**City of Portland, Maine - Building or Use Permit Application**  
 389 Congress Street, 04101 Tel: (207) 874-8703, Fax: (207) 874-8716

<b>Permit No:</b> 04-1308	<b>Issue Date:</b>	<b>CBL:</b> 376 A020001
------------------------------	--------------------	----------------------------

<b>Past Use:</b> Single Family Home	<b>Proposed Use:</b> Single Family Home / add 24'x24' garage	<b>Permit Fee:</b> \$129.00	<b>Cost of Work:</b> \$12,000.00	<b>CEO District:</b> 5
<b>Proposed Project Description:</b> add 24'x24' garage		<b>FIRE DEPT:</b> <input type="checkbox"/> Approved <input type="checkbox"/> Denied	<b>INSPECTION:</b> Use Group: Type	
		Signature:	Signature:	
<b>PEDESTRIAN ACTIVITIES DISTRICT (P.A.D.)</b>				
Action: <input type="checkbox"/> Approved <input type="checkbox"/> Approved w/Condition <input type="checkbox"/> Denied				
		Signature:	Date:

DETAIL OF SLAB AND INSULATION

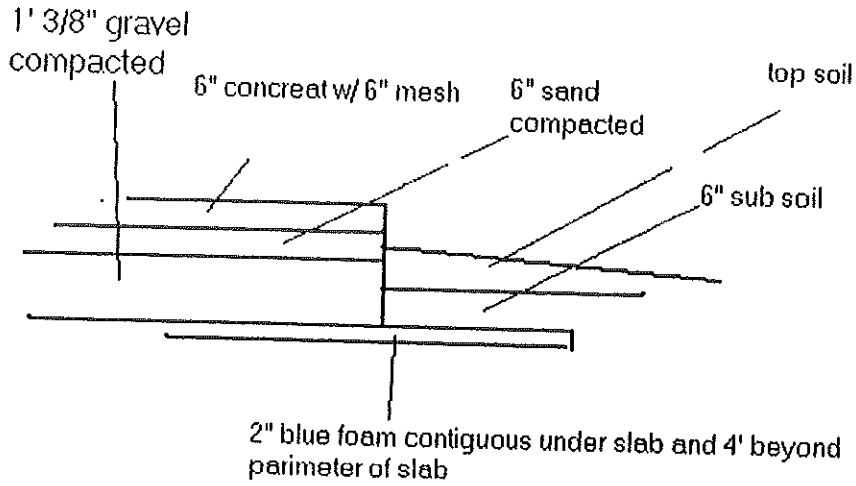
<b>Comments:</b>
9/23/04-tmm: need better detail on slab, headers, anchor bolts size and spacing, and sill sealer? Left message w/builder and owner.
9/29/04-tmm: spoke w/owner - left message w/builder.

<b>Dept:</b> Zoning	<b>Status:</b> Approved	<b>Reviewer:</b> Tammy Munson	<b>Approval Date:</b> 09/29/2004
<b>Note:</b>			<b>Ok to Issue:</b> <input checked="" type="checkbox"/>
<b>Dept:</b> Building	<b>Status:</b> Approved with Conditions	<b>Reviewer:</b> Tammy Munson	<b>Approval Date:</b> 09/29/2004
<b>Note:</b>			<b>Ok to Issue:</b> <input checked="" type="checkbox"/>
1) Permit approved based on the plans submitted and reviewed w/owner/contractor, with additional information as agreed on and as noted on plans.
